From: [REDACTED]
To: [Sunnica Energy Farm](#)
Subject: Deadline 6 Submission Isleham Society
Date: 30 January 2023 17:38:41

From the Isleham Society to the Examining Authority

Drawing Title
**FIGURE 10-14B
LANDSCAPE MASTERPLAN
SUNNICA EAST SITE A**

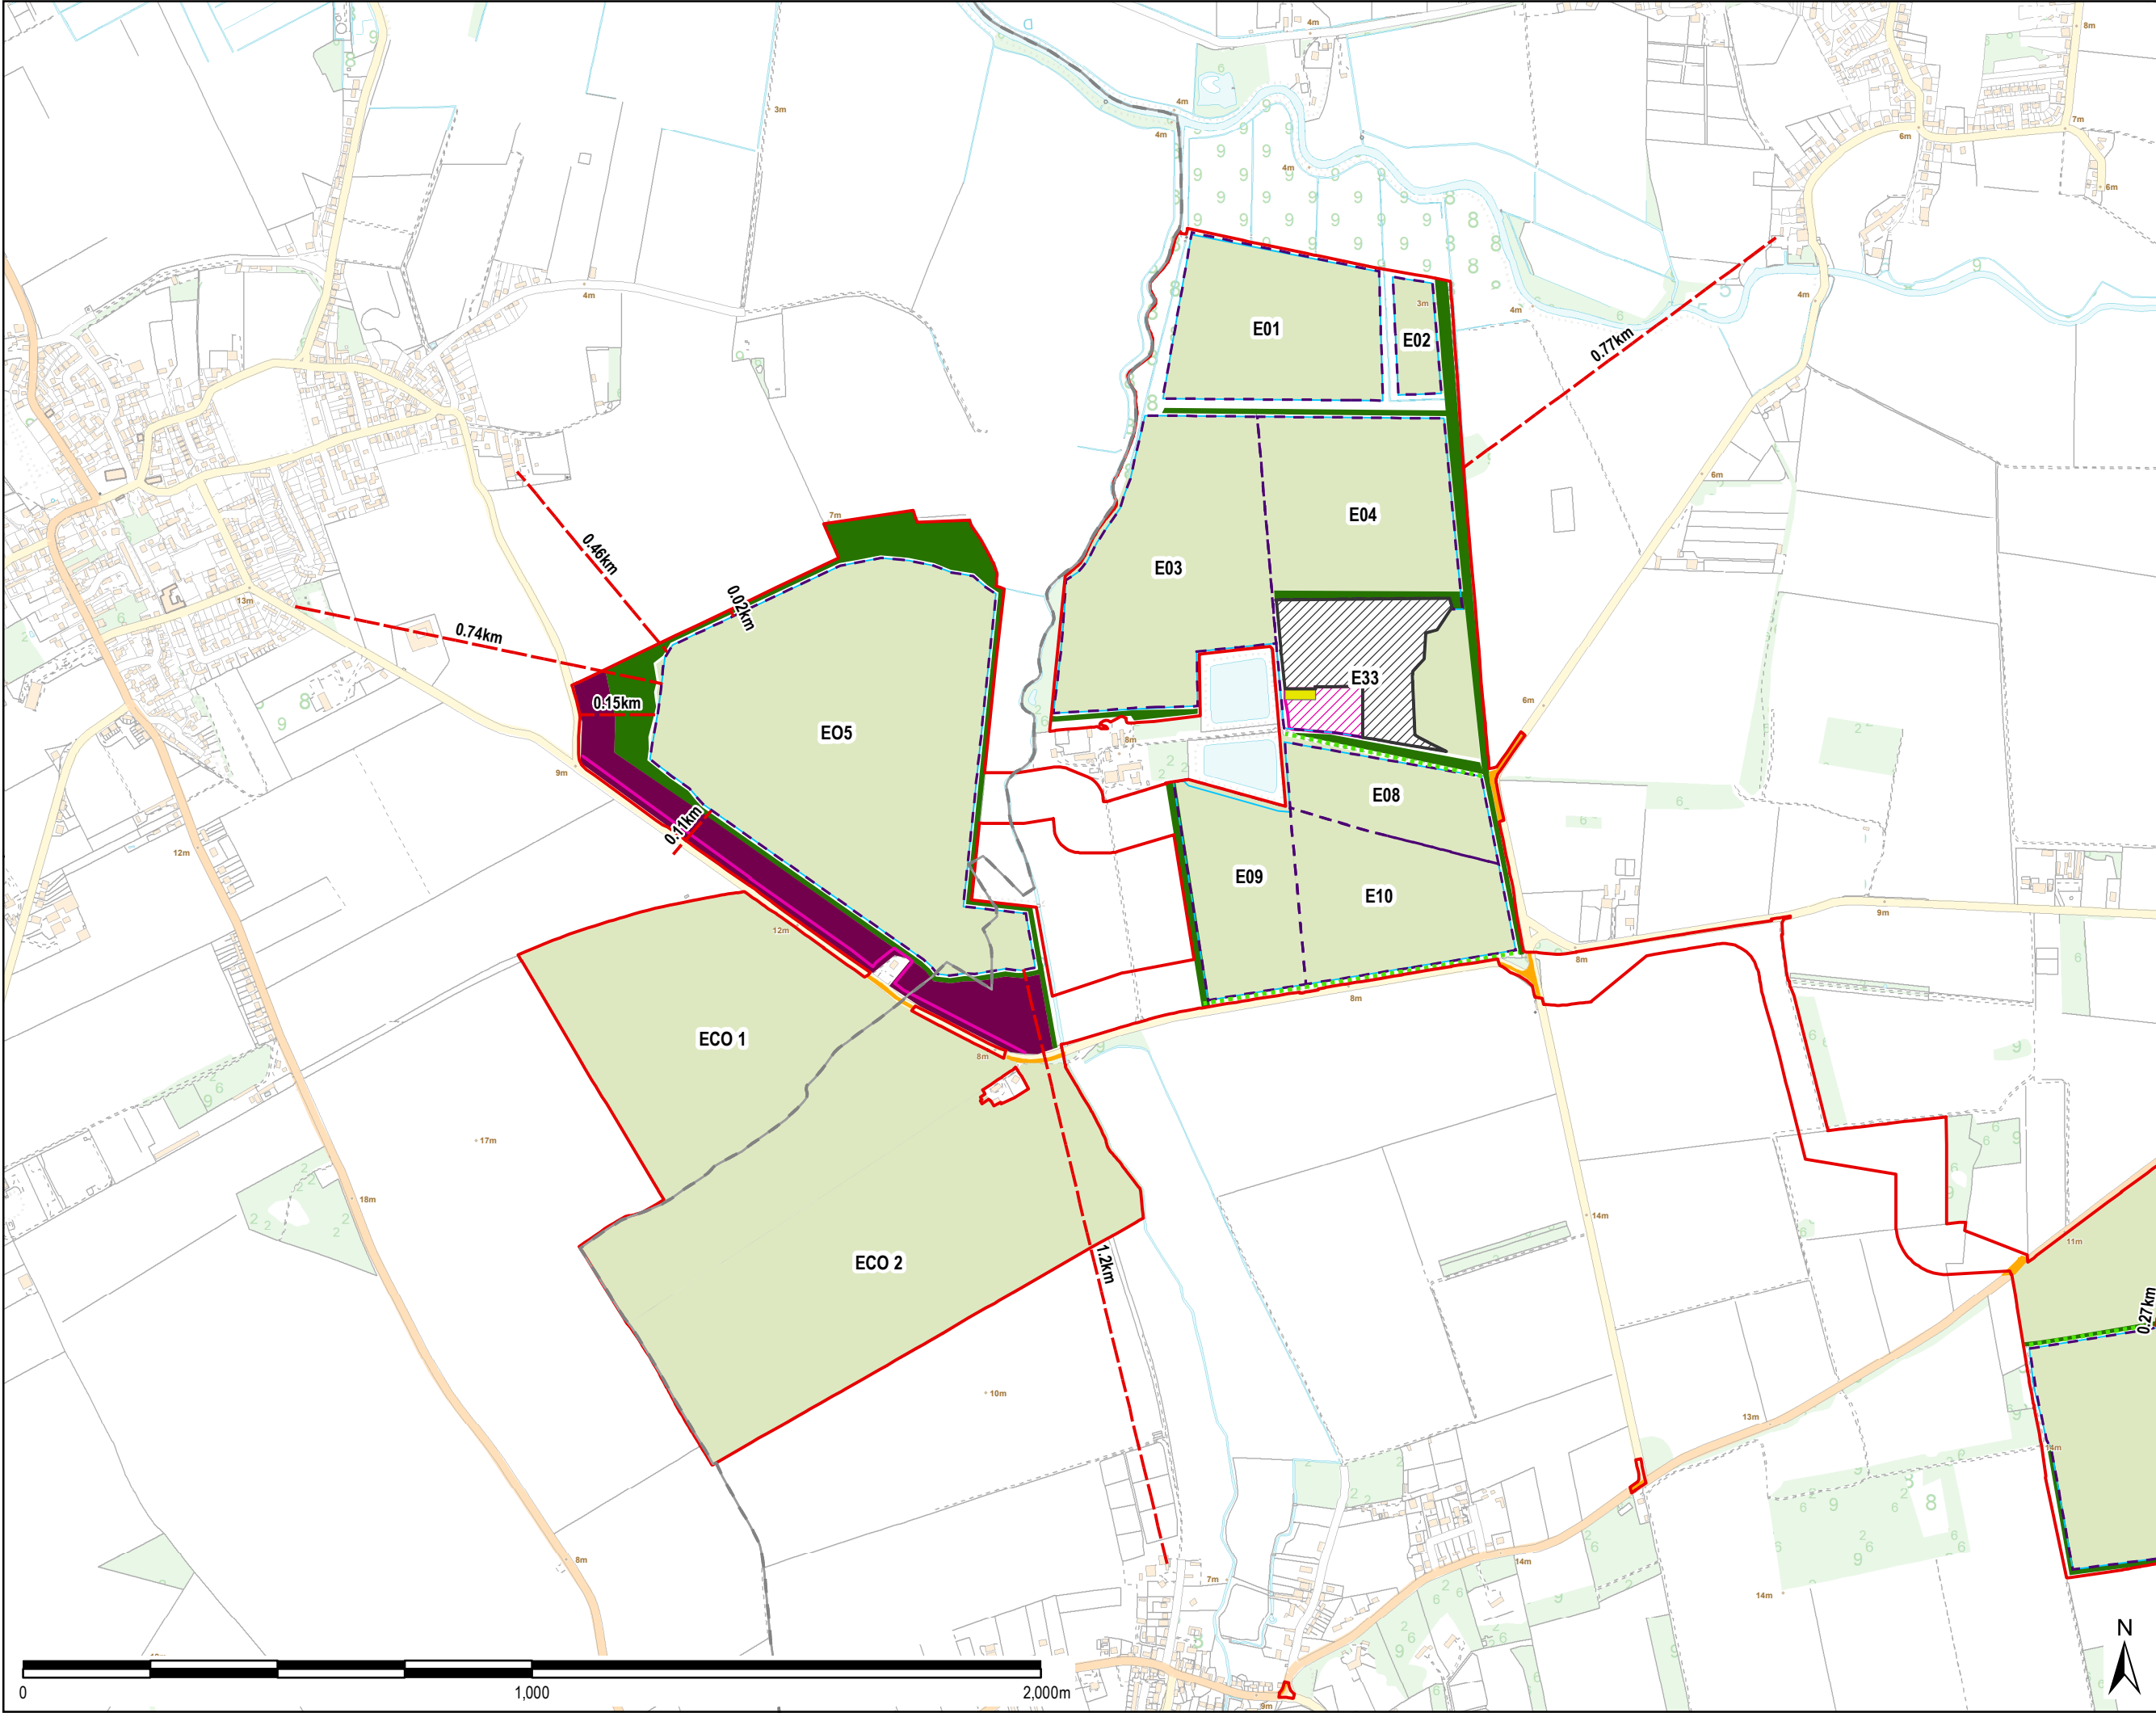
However, on this occasion attention was focussed specifically on considering the new proposals for E05, the site of the 1949 Bomber crash. The sense that at least Sunnica might be beginning to realize the importance of this site to the village was welcomed.

However the unanimous opinion of the thirty members present was that a preserved area of 50m around the crash impact crater would not be sufficient to preserve the special nature of that historic landscape as viewed from the Ark, Sheldrick's Rd and Beck Rd towards Worlington.

Neither would a 100m radius if the rest of E05 were to be covered by panels.

In conclusion, the main request of the Isleham Society is that, as the Councils have requested, E05 should not be developed and should be withdrawn from the Sunnica plan.
